East Anglia ONE North and East Anglia TWO Offshore Windfarms

Applicants' Comments Suffolk County Council's Deadline 6 Submissions

Applicant: East Anglia TWO and East Anglia ONE North Limited
Document Reference: ExA.AS-11.D7.V1
SPR Reference: EA1N_EA2-DWF-ENV-REP-IBR-001341

Date: 4th March 2021
Revision: Version 01
Author: Royal HaskoningDHV

Works Nos. 19 and 20 - B1122 Aldringham Cable Corridor & R. Hundred Crossing EA1N/ EA2 Works Plan Onshore Sheet 5 of 12

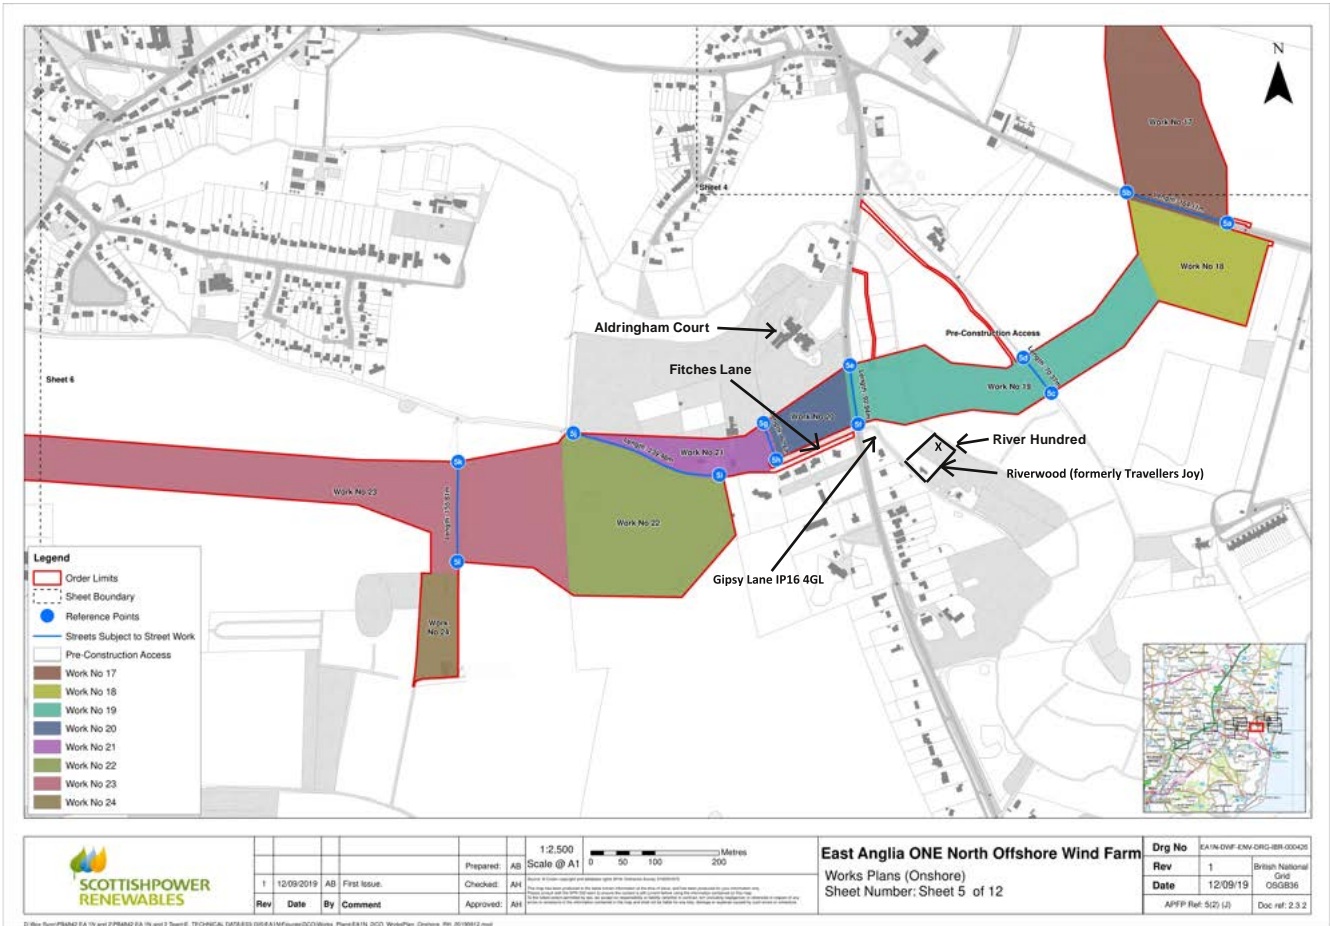
<i>Schedule 2- Streets Subject to Streetworks</i>		
17	3.17 The B13153 between 5a and 5b on the land plans (onshore) is recorded as Thorpe Road rather than Thorpeness Road stated in the schedule.	The Applicants note that Schedule 2 of the dDCO (document reference 3.1) refers to the Works Plans (Onshore) (REP3-006) rather than the Land Plans (Onshore) as cited by SCC in their comment (REP1-004). The Works Plans (Onshore) (REP3-006) do not present road names and Schedule 2 has been amended within the updated draft DCO submitted at Deadline 7 (document reference 3.1) to refer to 'Thorpe Road' instead of 'Thorpeness Road' in relation to points 5a and 5b on Sheet 5 of 12 of the Works Plans (Onshore) (REP3-006).

ID	SCC Comment	Applicants' Comments
23	3.23 The length of B1122 Aldeburgh Road to be stopped up is between points 5e and 5f recorded as 23m in the schedule and 92.94m on sheet 5 of the works plans (REP3-006).	The Applicants can confirm that the distance of 92.94m is correct. The Applicants have updated the length between 5e and 5f in Schedule 5 of the dDCO (document updated at Deadline 7, document reference 3.1) from 23m to approximately 93m to reflect the length stated on Sheet 5 of the Works Plans (Onshore) (REP3-006).
24	3.24 The comments relating to street names made for Schedule 2 also apply to this schedule. This will require the A1094 Aldeburgh Road between points 10a and 10b to be split at 10d on the page 10 of the works plans.	The Applicants have submitted an updated dDCO at Deadline 7 (document reference 3.1) with the road names, Aldeburgh Road, Farnham Road and Friday Street, in Schedule 5 amended. These updates will also be reflected in the updated Works Plans (Onshore) submitted at Deadline 7 (document reference 2.3.2).
